WA/75/22/DOC

A proposed drainage strategy for the whole site and some detailed information has been provided. As has a verification report for a first phase of development (installed).

At this time, we **do not** recommend discharge of conditions until the following has been provided:

Stainless steel drainage pumps

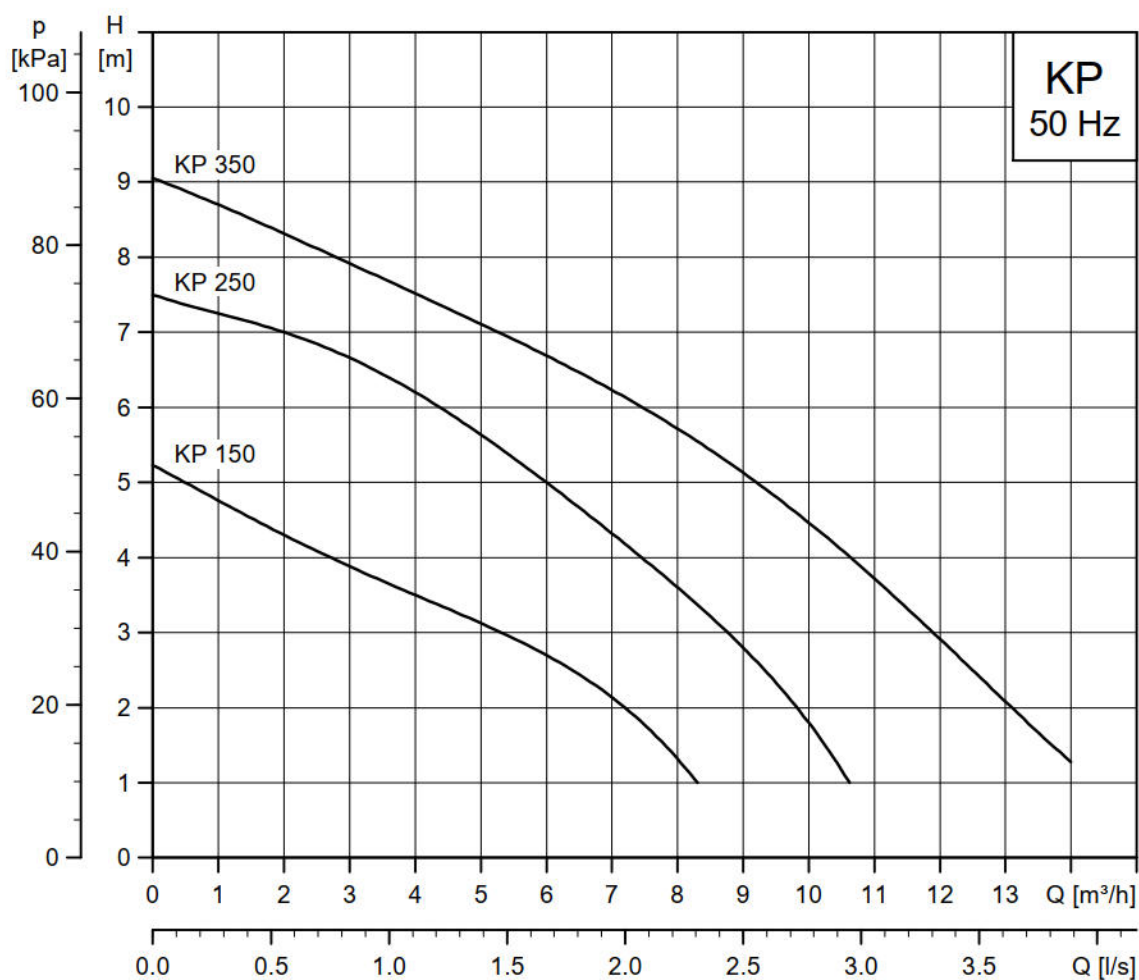
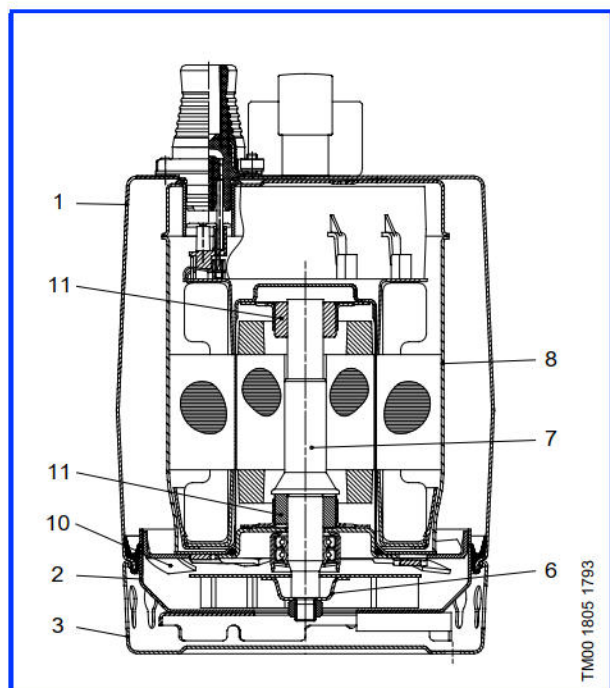
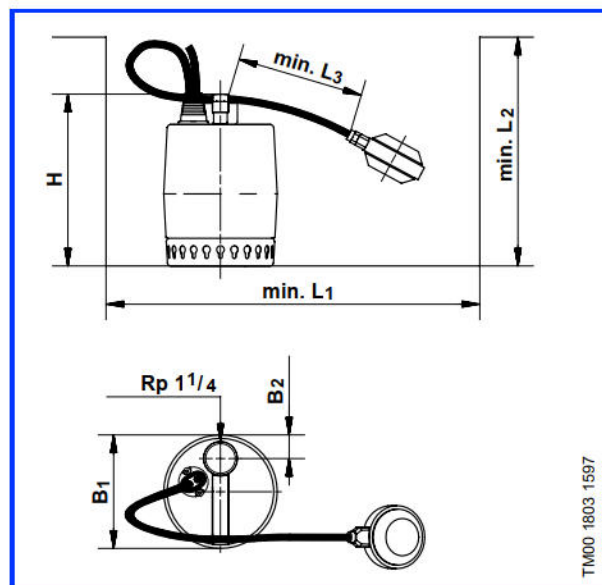
- 4) Details of exactly how the sump and pump system operate are required to better understand how this is used to drain down the outfall from each tank, and why this is required. This is to ensure that the tanks cannot be full prior to the onset of an extreme rainfall event.

- Full construction drawings in addition to the product specific schematics provided.
 - Details of the pump.
 - Drawings of the outfall from the tanks must be provided, this should include a cross section / long section showing the tank in relation to the sump pump (for drain down) and the flow control devices (orifice plates), and outfall. It is currently unclear how the orifice plates relate to the sump / pump system and thus there is uncertainty whether the pumped runoff could enter the ditch during an extreme rainfall event.

Drainage
Invert levels & pipe details

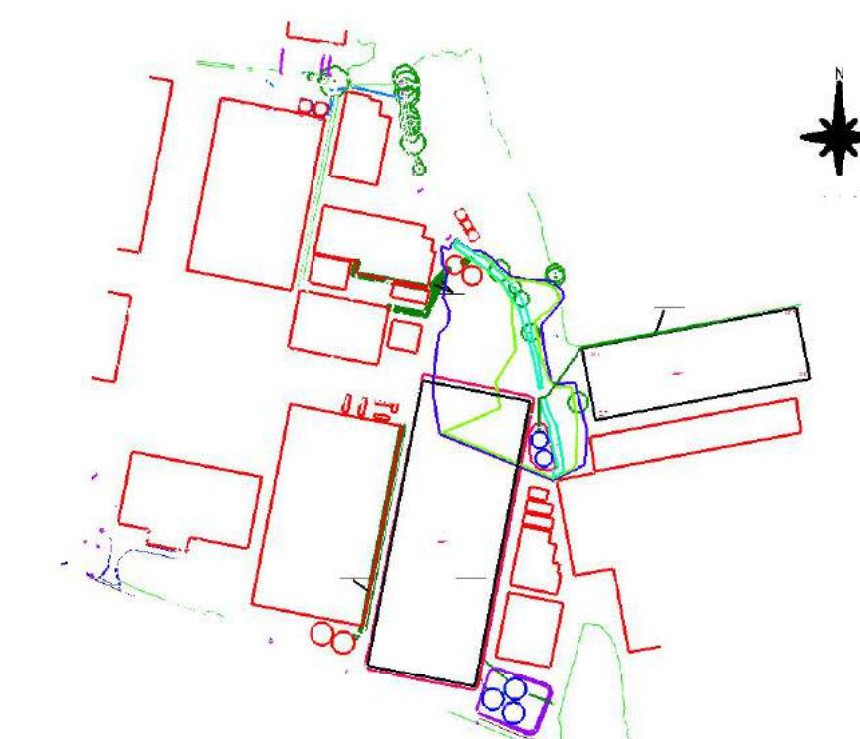
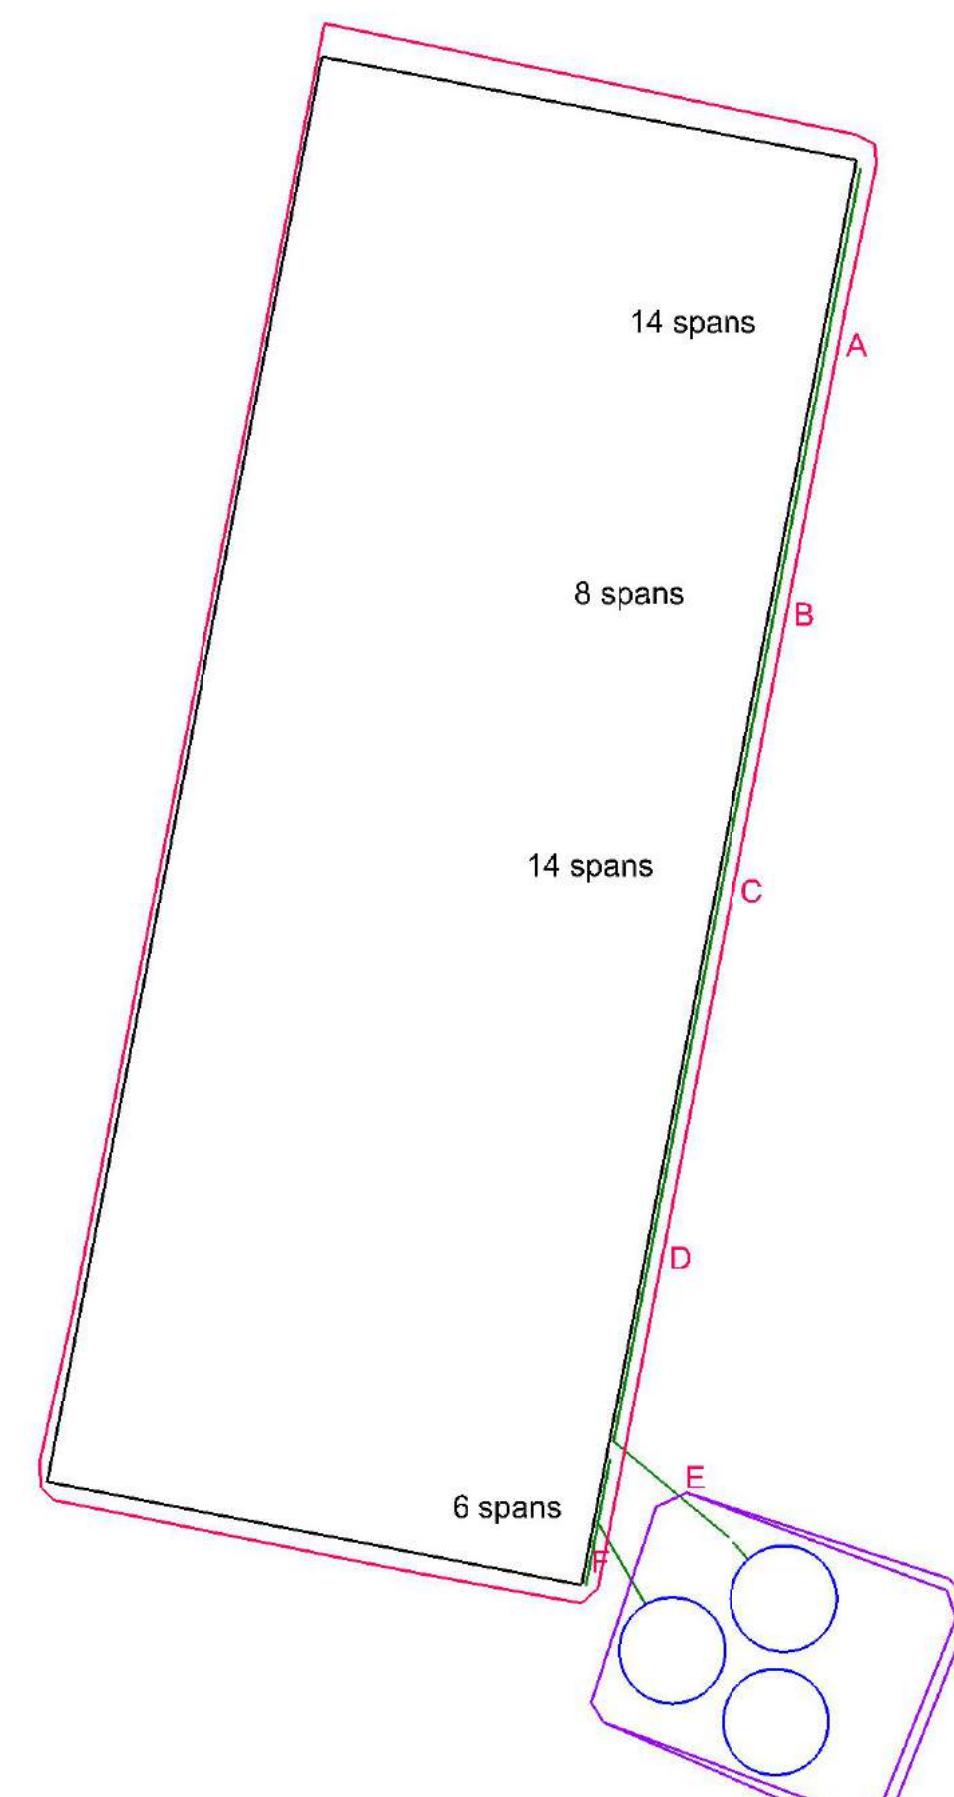
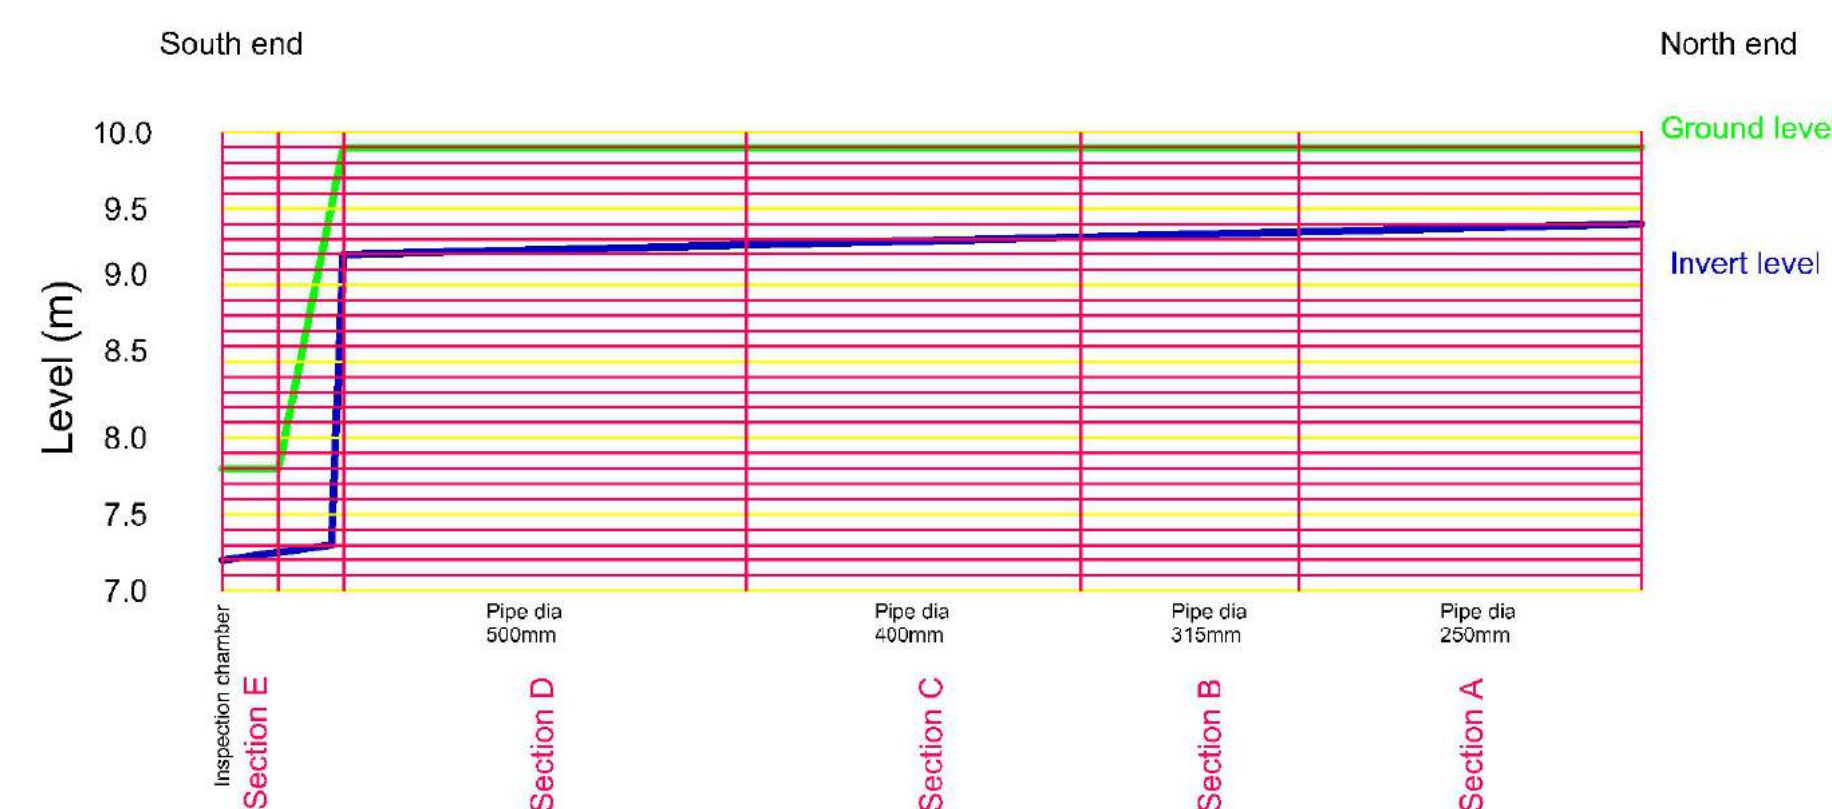
- Ground levels, invert levels, and cover levels must be provided on the drainage drawings.
 - Technical drawings for the outfall(s) must be provided.
 - 6) A flap valve on the outfall(s) must be provided (to prevent backflow of water from the ditch network(s) entering the drainage system)

Drainage
Overall site layout

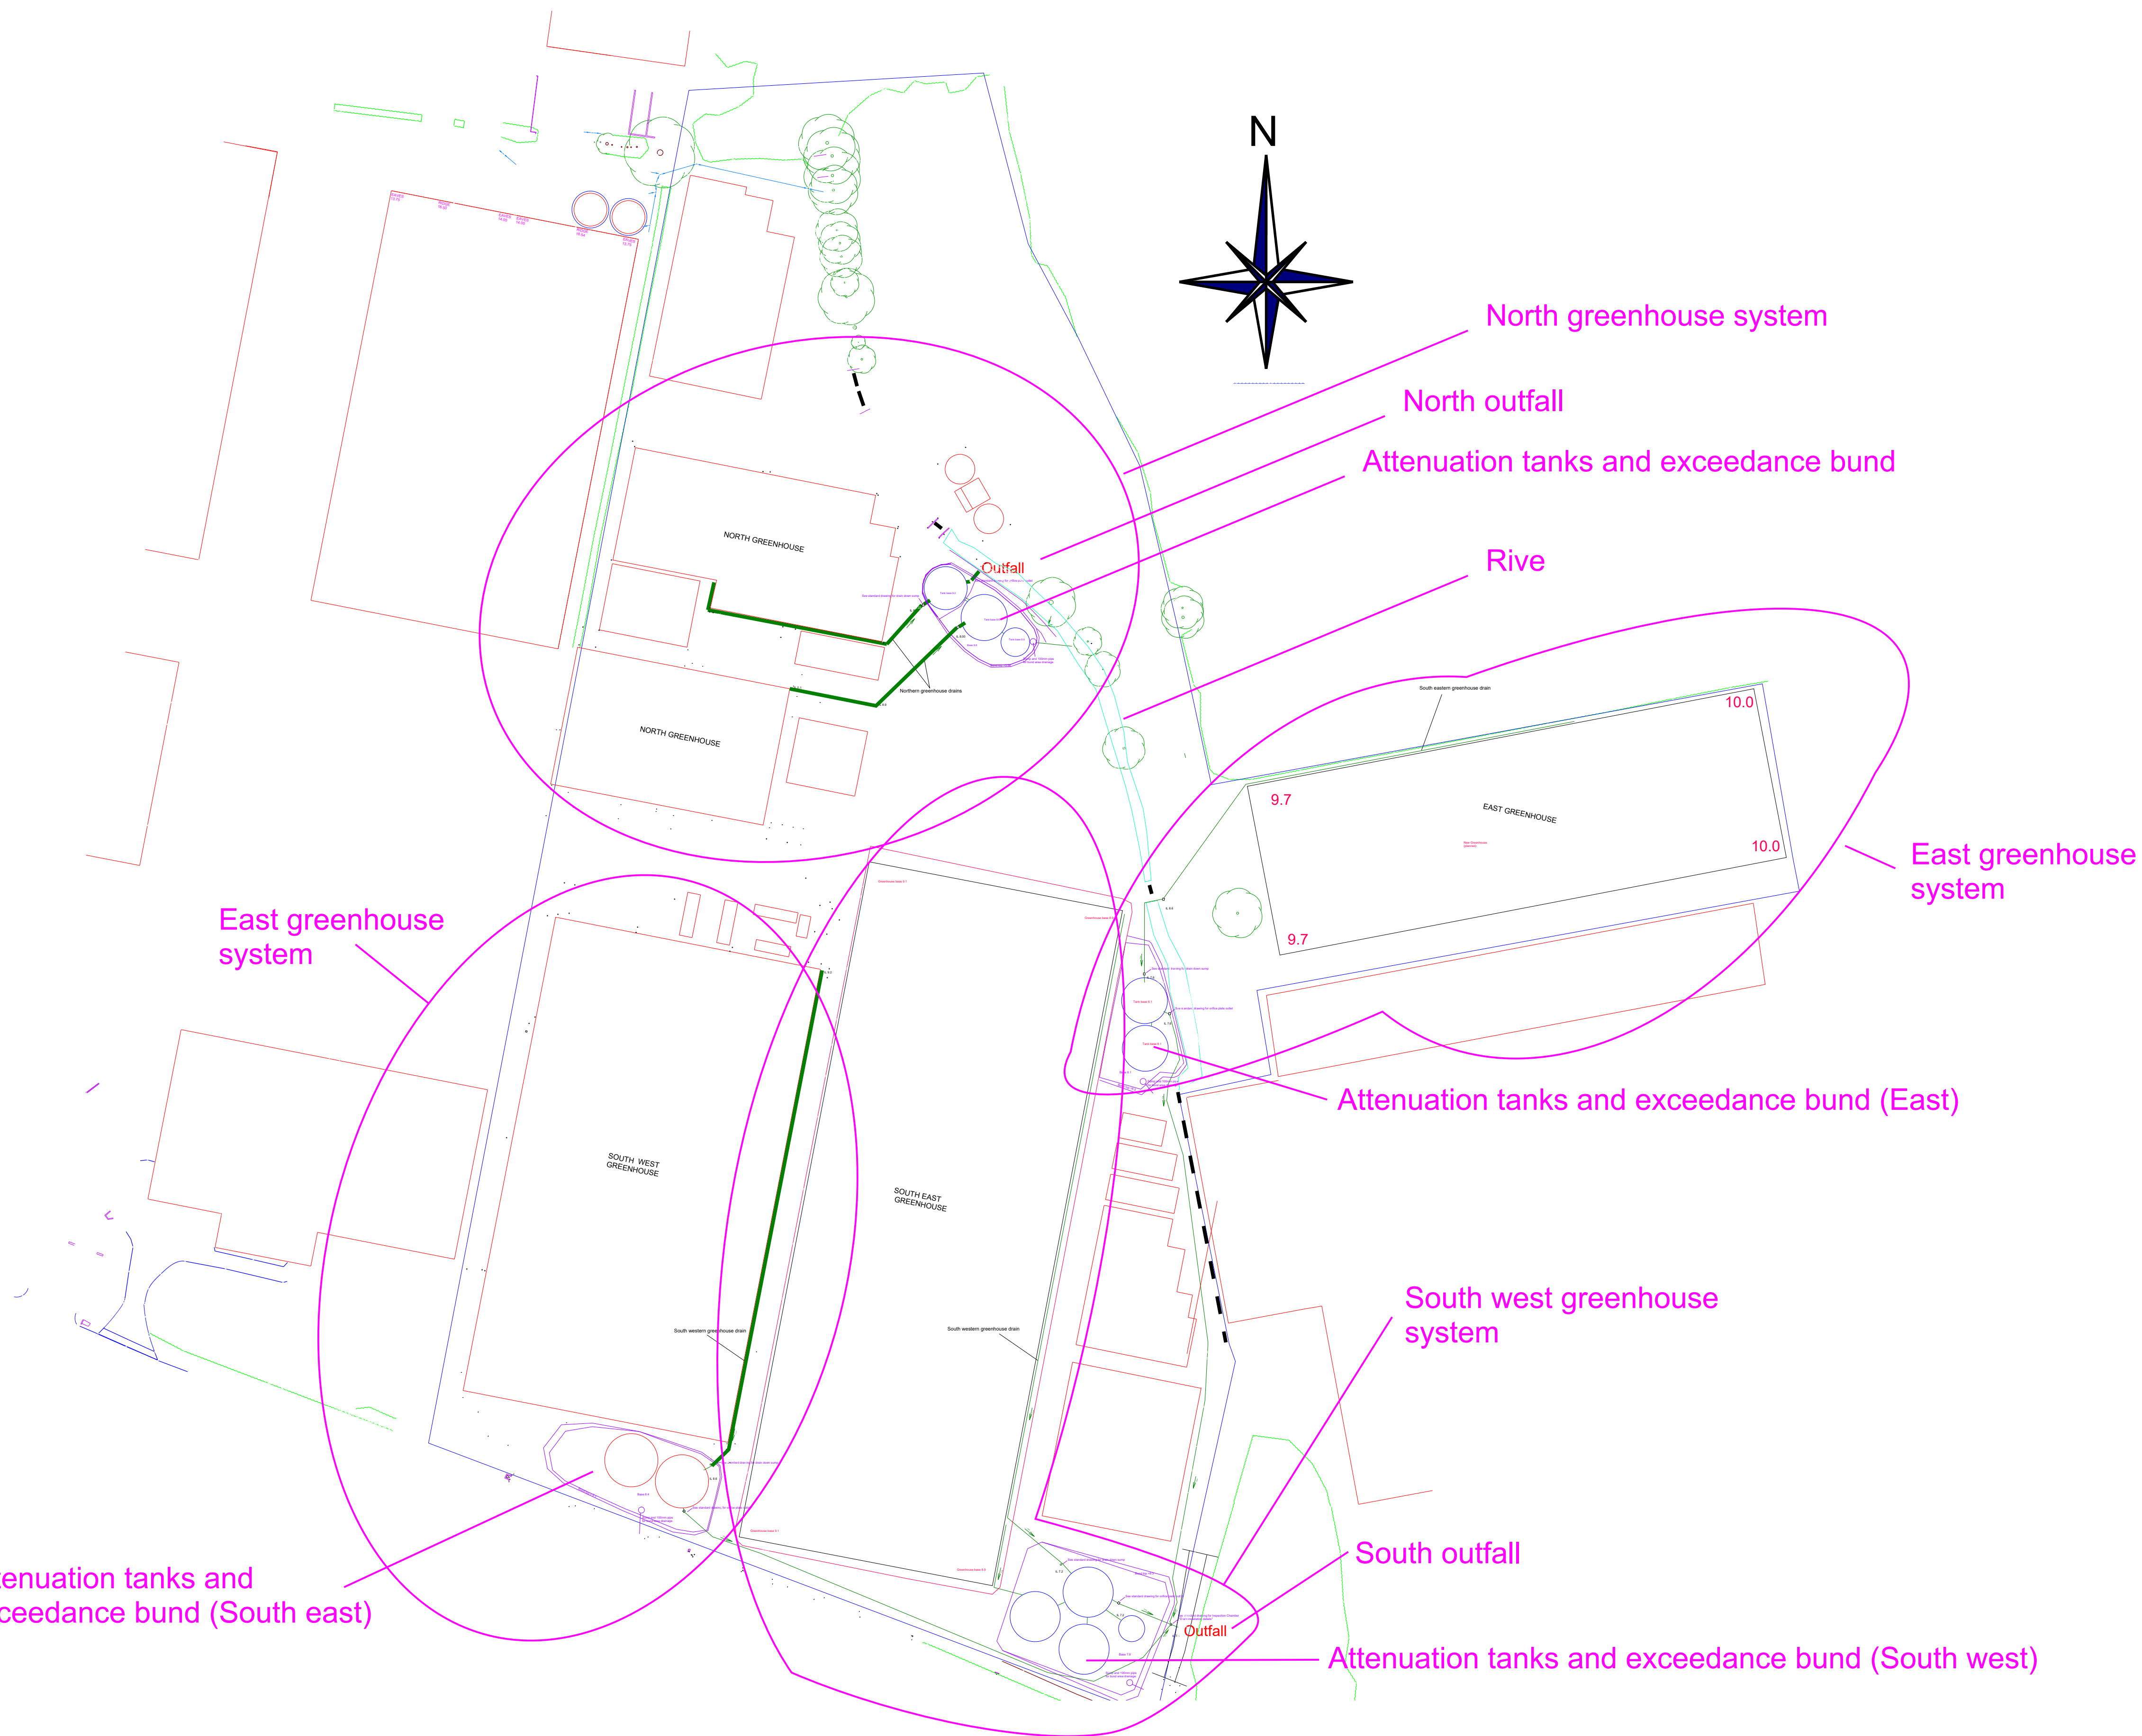
- 7) We have previously requested information relating to exceedance events and possible failure of the tanks. Given the large volumes of storage involved we would expect details of the exceedance flow routes and safety practices to be carried out to protect on and offsite occupants from the potential failure of the tanks.
- 8) The FRA report makes reference to trafficked areas being, “stoned or permeable tarmac”, these areas need further consideration and details of the surfacing and sub-base material needs to be provided. As infiltration has been ruled out it is also likely that a separate outfall for these areas will be required and details of this should be available for review.
